**KIRKLEES METROPOLITAN COUNCIL  
INVESTMENT & REGENERATION SERVICE**

Reference No:	<b>2023/44/93236/W</b>
Site Address:	Pentlands, New Mill Road, Holmfirth, HD9 7LN
Description:	Discharge of conditions 4 (internal estate road details), 5 (parking bay surfacing and drainage), 9 (temporary waste measures), 11 (surface water drainage details), 12 (overflow event scenario), 13 (separate drainage), 15 (temporary drainage measures), 22 (ecological enhancement plan) of previous permission 2020/91896 for demolition of existing dwelling and erection of 15 dwellings with associated access and external works
Recommending Officer:	William Simcock

## Officer Report 2023/93236

### Pentlands, New Mill Road, Holmfirth HD9 7LN

Site Entrance Visibility Splay (2.4m x 70m)
(SCALE 1:250)

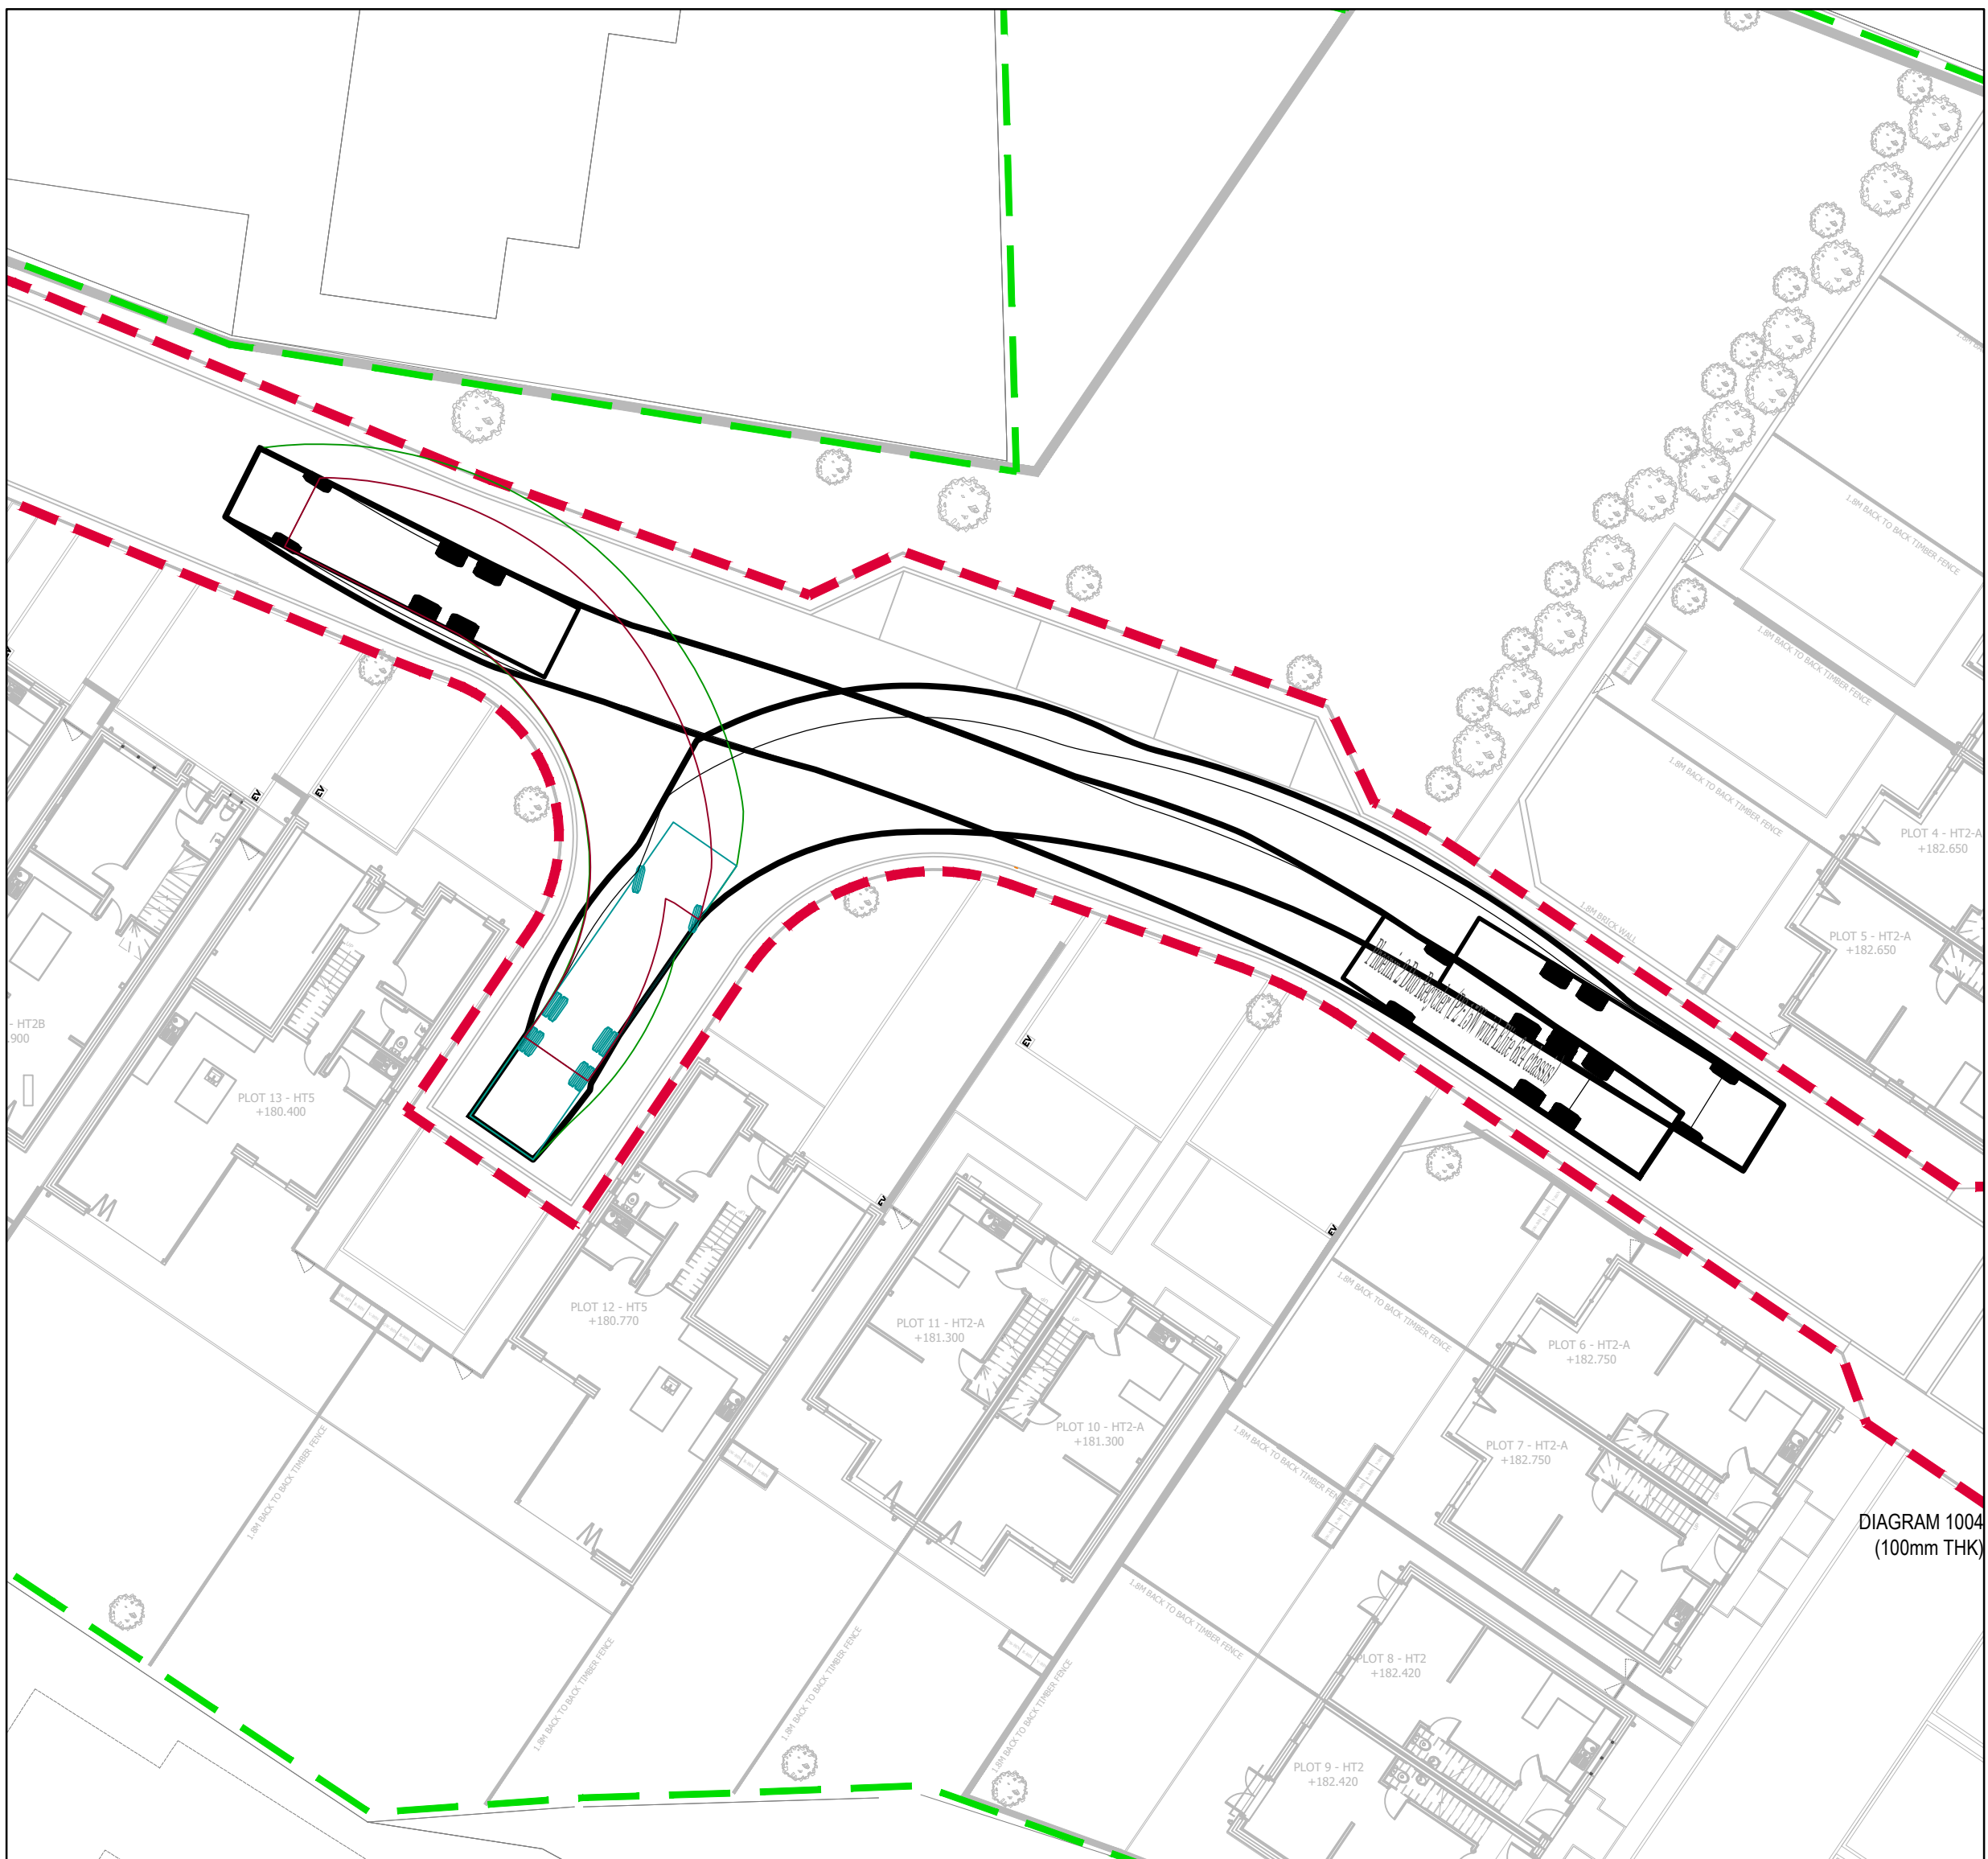
KC Highways Development Management have informed the case officer that these proposals will require a separate formal Technical Approval by the Council's Highways Section 38 Team. The council's section 38 Engineer confirms that technical approval has been applied for, but not yet granted, for the proposed section 38 Agreement. This condition cannot therefore be discharged at the present time.

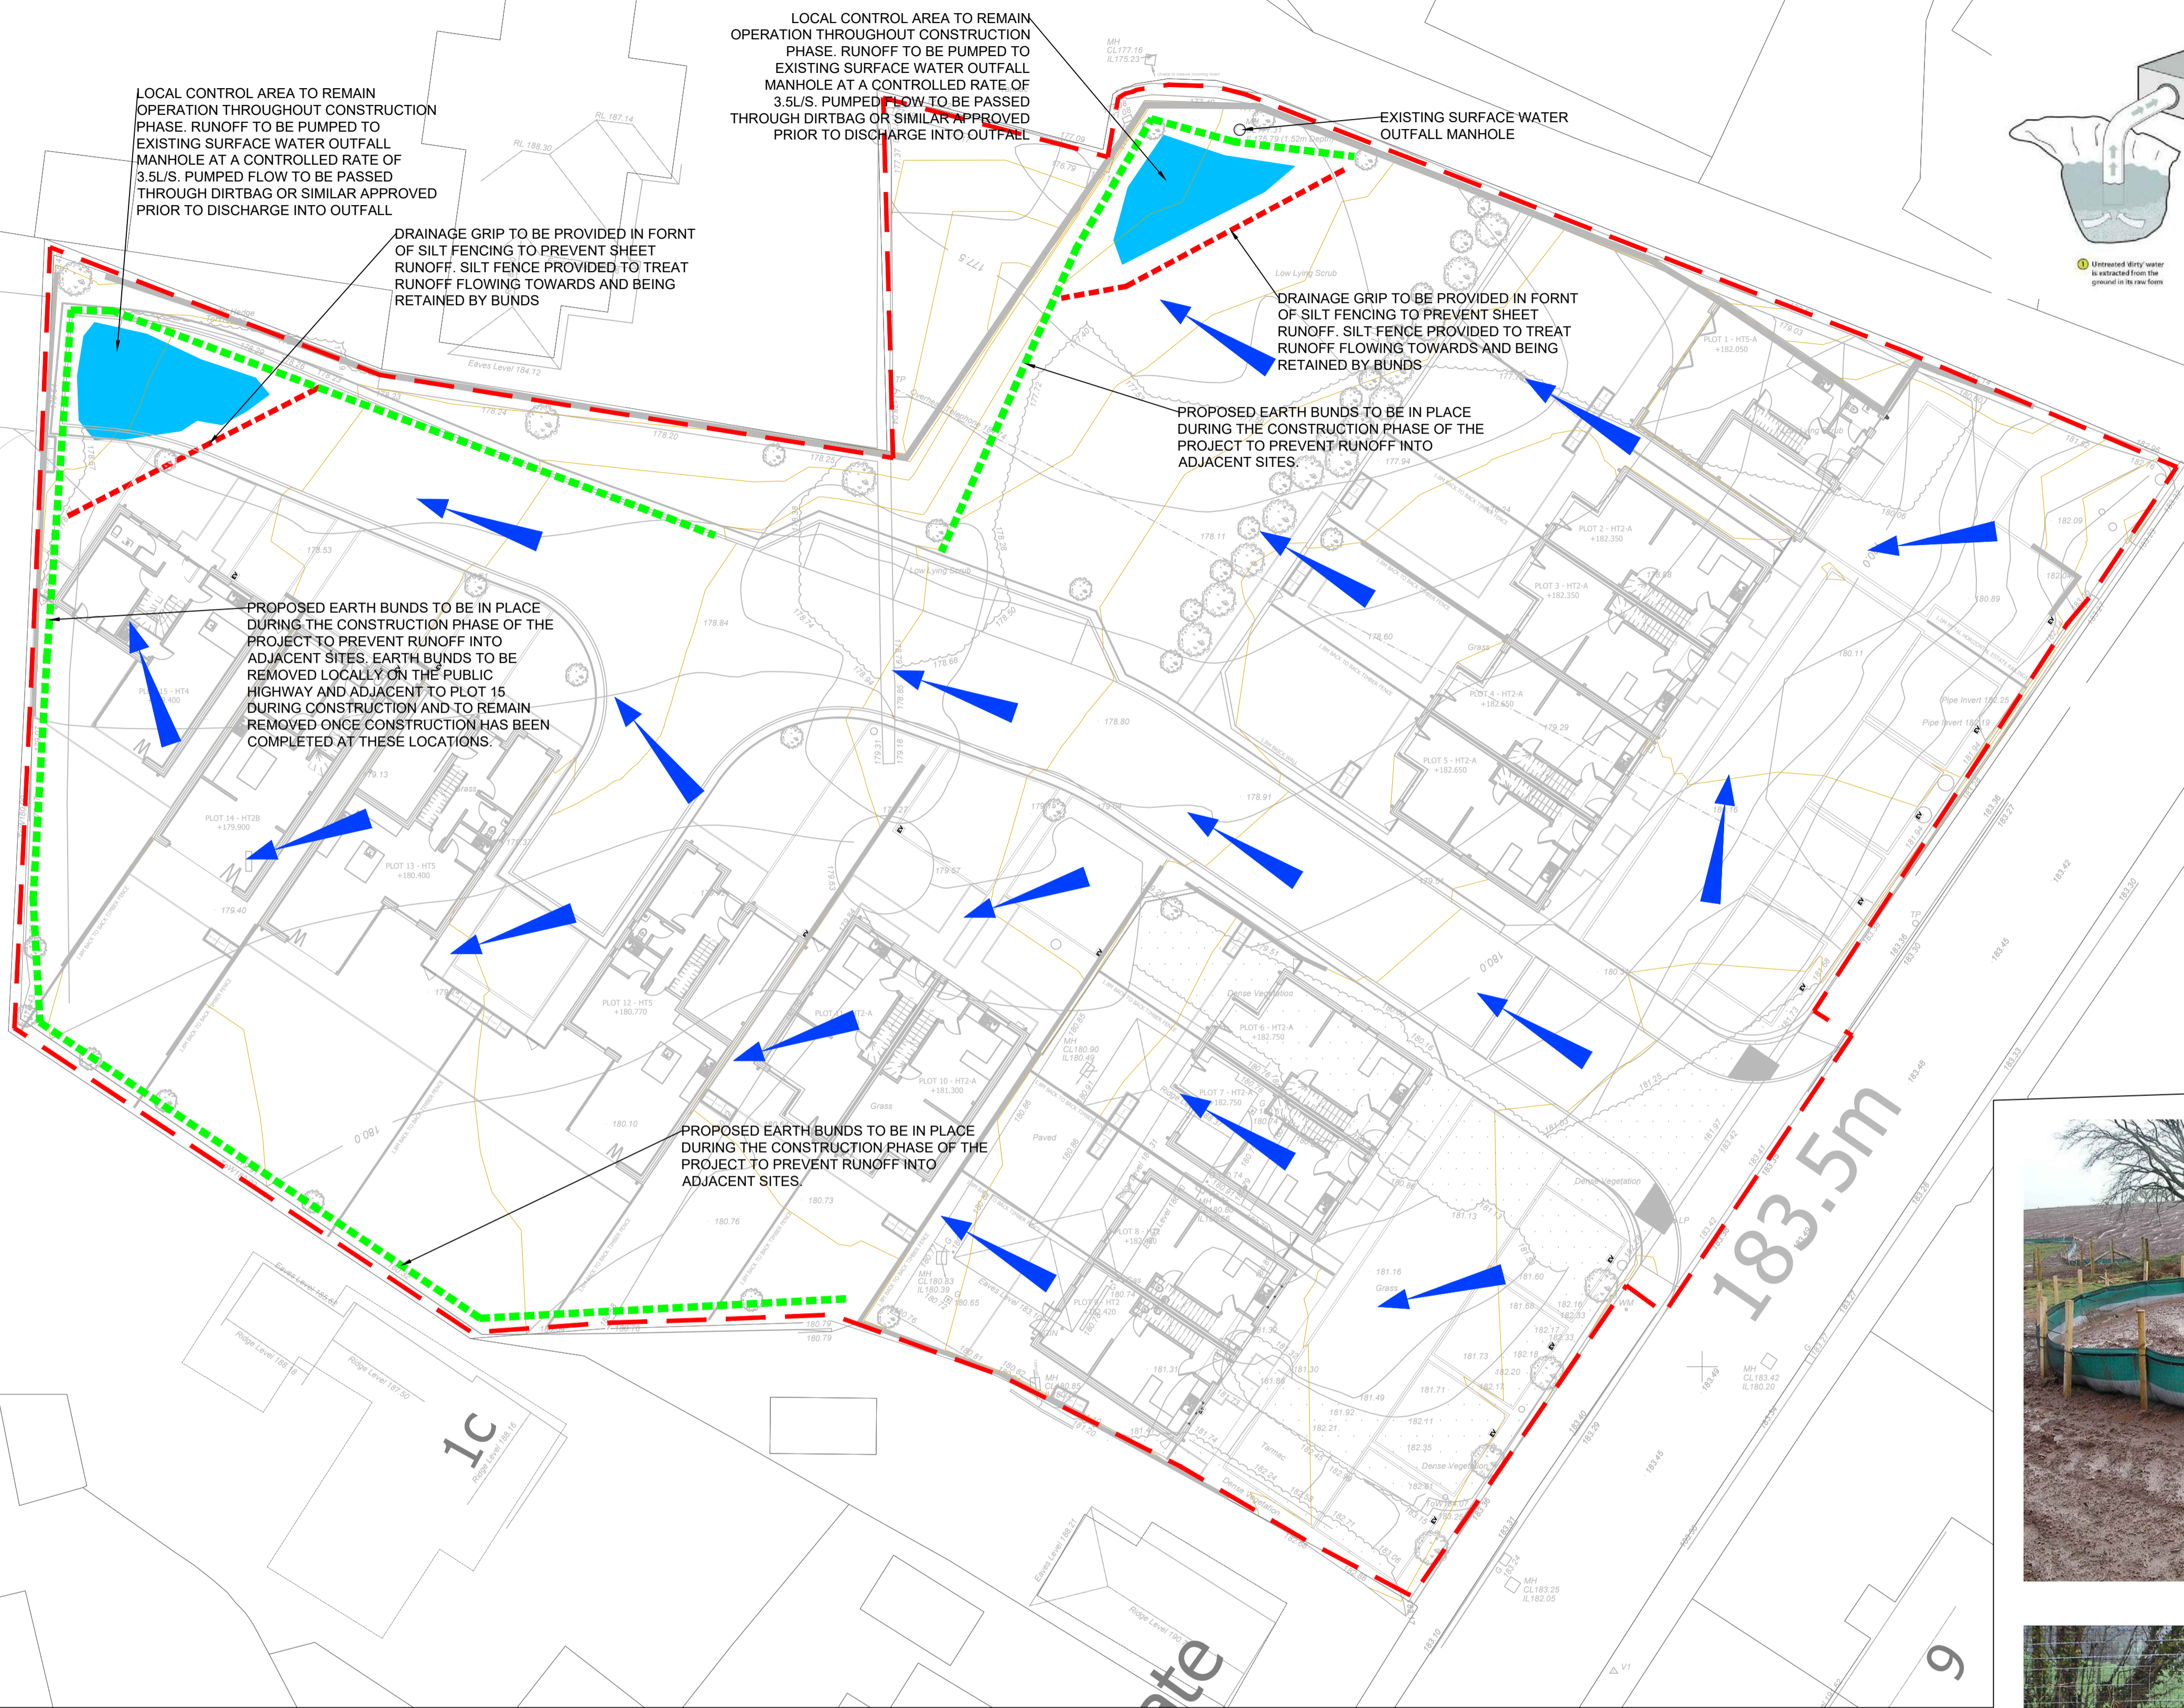
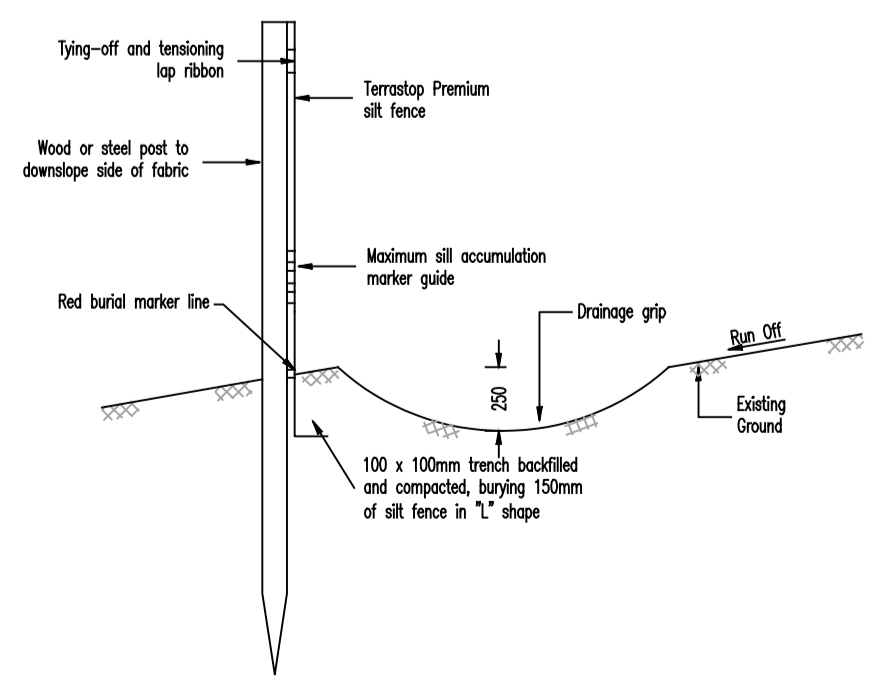
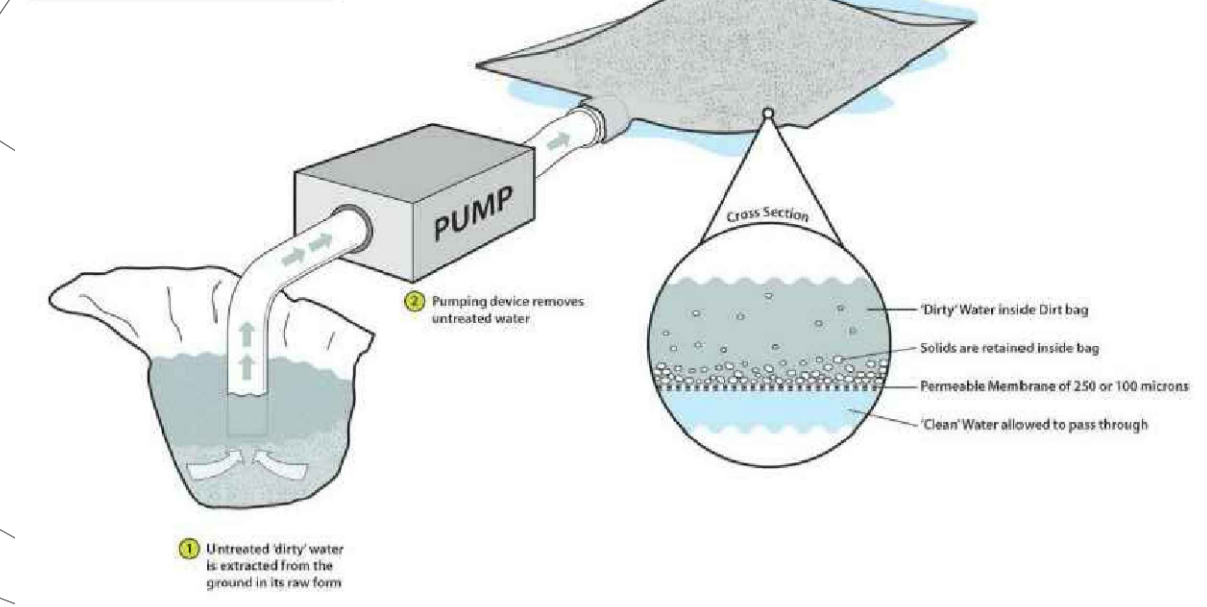
In response to the initially submitted details, the Lead Local Flood Authority (LLFA) raised several concerns, including regarding a lack of clarity on flow control numbers, lack of detail concerning tank design, and absence of a maintenance plan, and also stated that no connection to watercourse on the Midlothian site can be allowed until such a time that the adjacent building site has completed its connection to the open watercourse to the northwest of site.

Additional and amended drawings were submitted (15/02/2024) including attenuation tank details. Yorkshire Water confirm they now have no objections in respect of condition 11. The views of the (LLFA) in respect of the updated plans and details in respect of conditions 11-13 and 15 have been sought, and are awaited. These conditions cannot be discharged at the present time.
